**A-1 CHIPSEAL**  
GRADING AND EROSION CONTROL PLAN  
**PROPOSED SAND FILTER**  
MAY 2022

A-1 CHIPSEAL	GRADING AND EROSION CONTROL PLAN PROPOSED SAND FILTER
--------------	--

DESIGNED BY	DLF
DRAWN BY	DLF
CHECKED BY	LD
H-SCALE	AS SHOWN
V-SCALE	N/A
JOB NO.	2173.00
DATE ISSUED	05/02/2011
SHEET NO.	3 OF 5

A-1 CHIPSEAL GRADING AND EROSION CONTROL PLAN GRADING PLAN MAY 2022

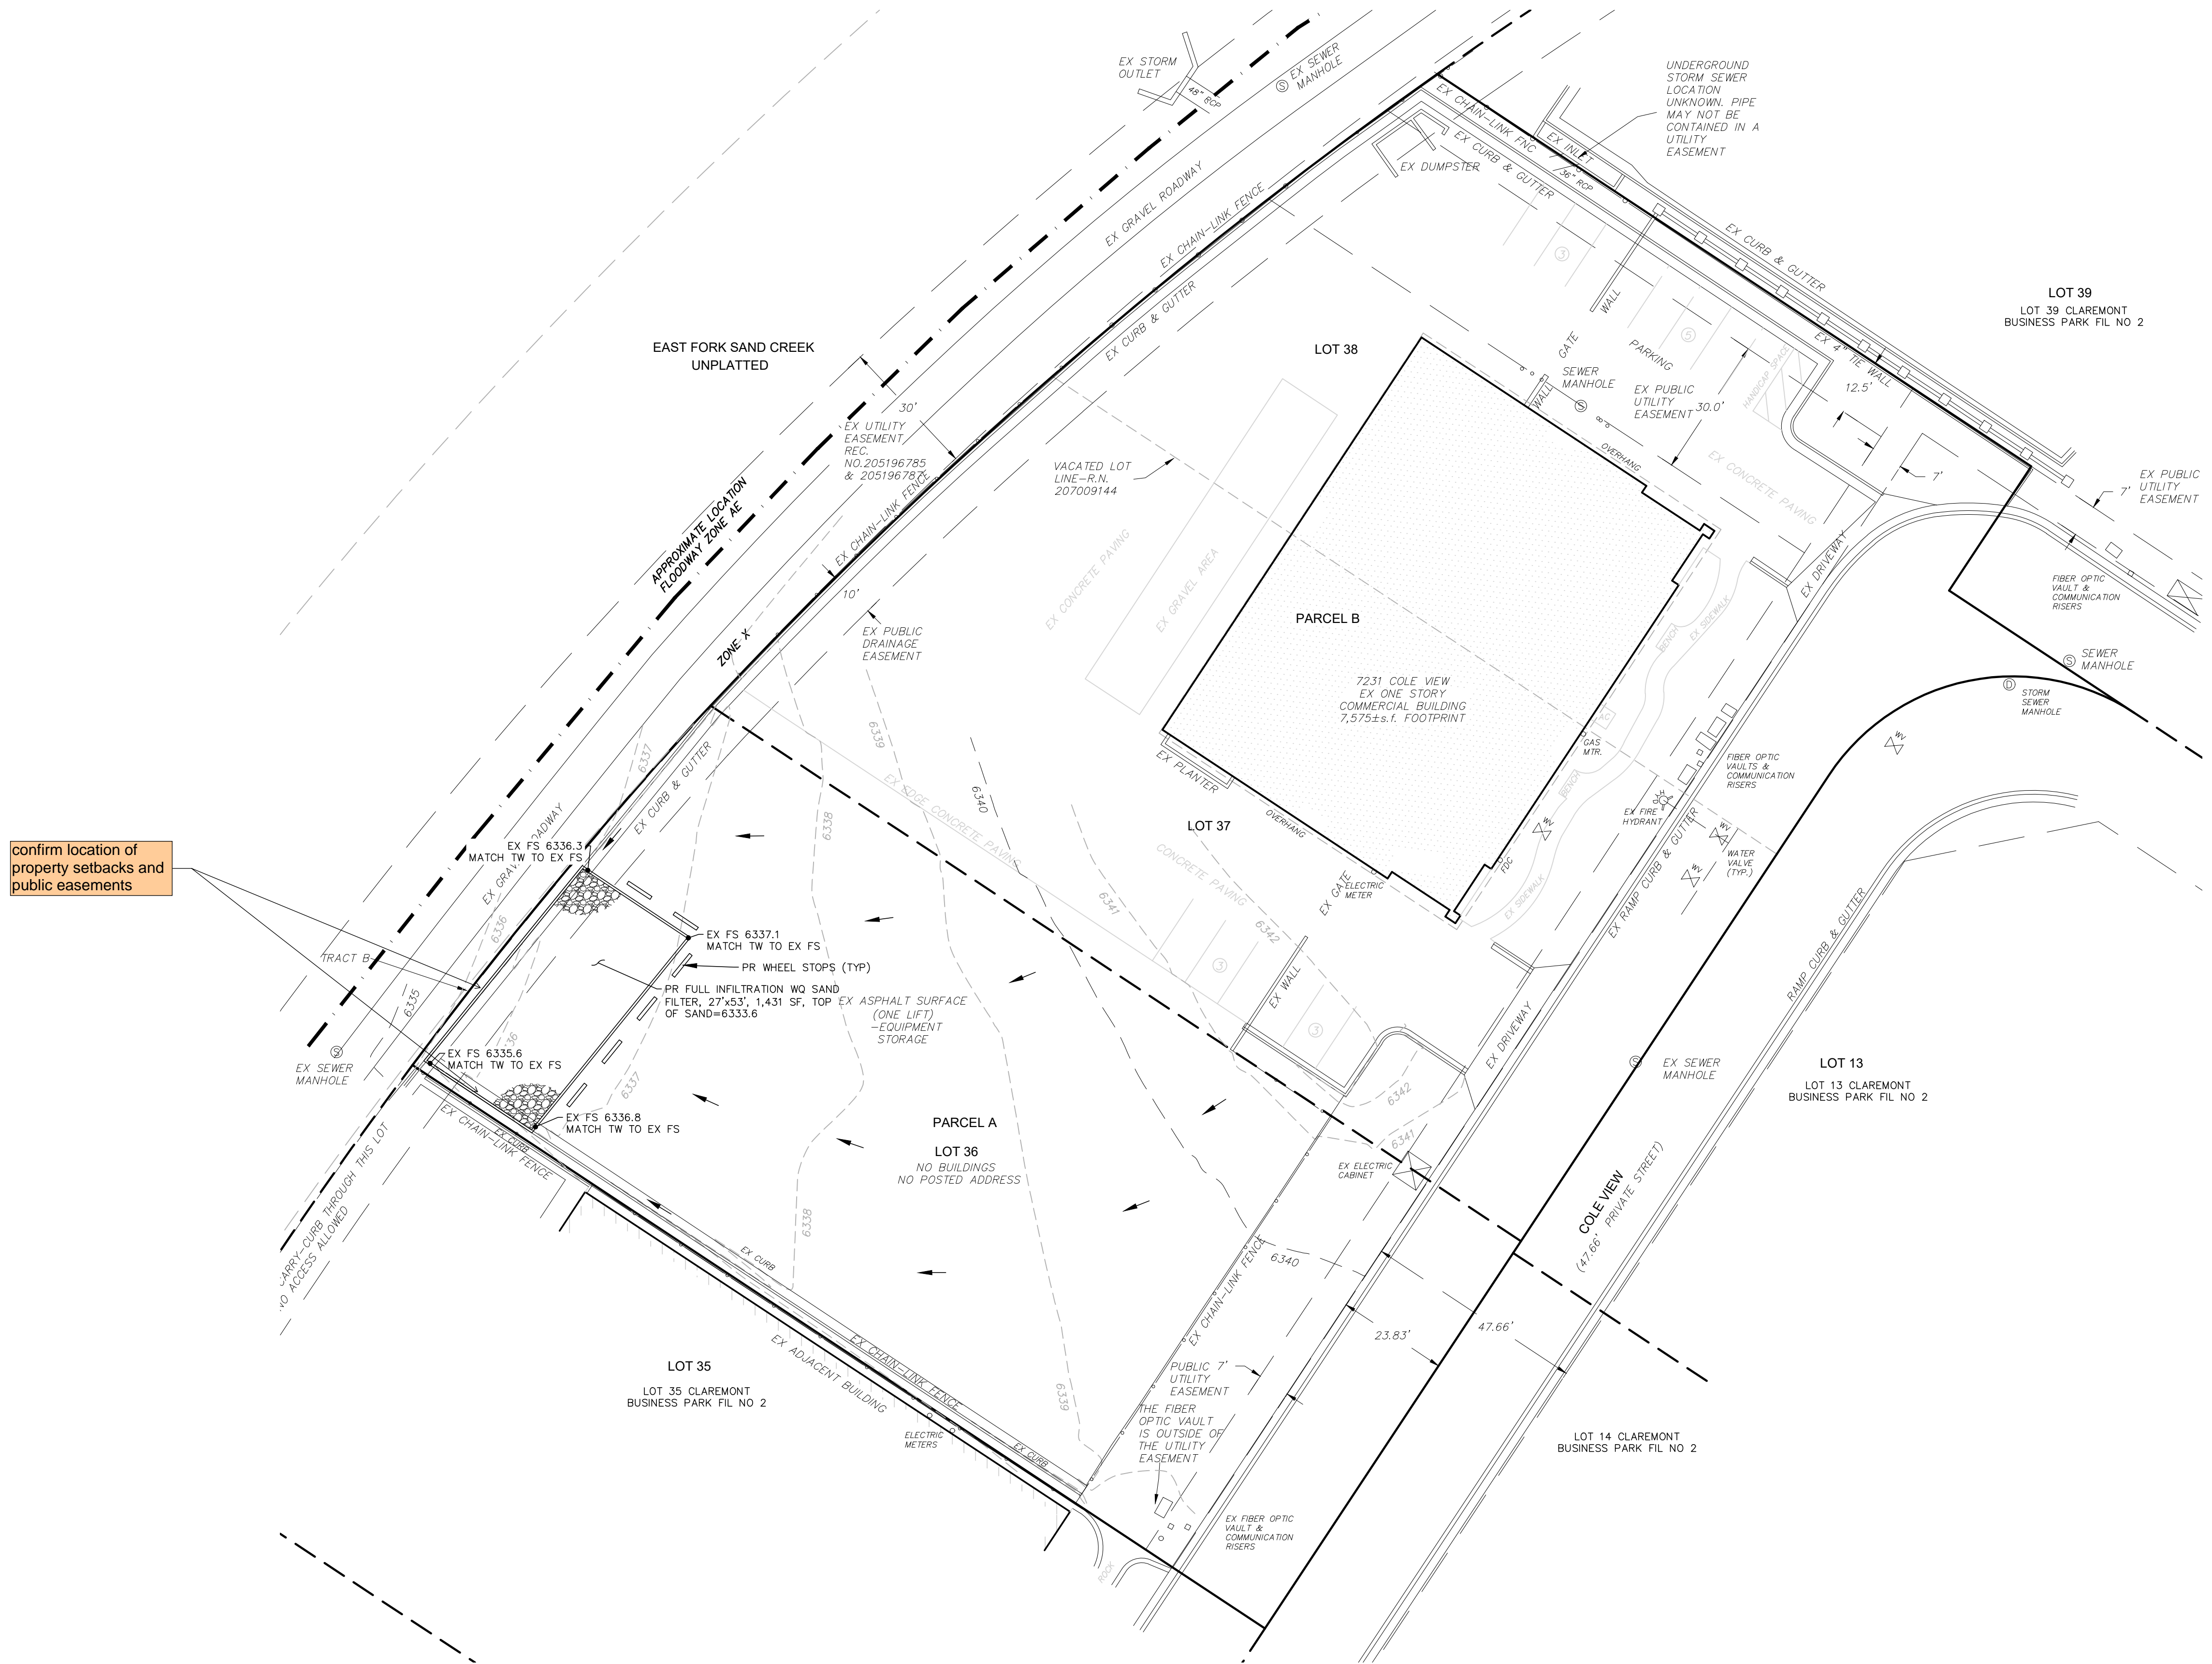
confirm location of  
property setbacks and  
public easements
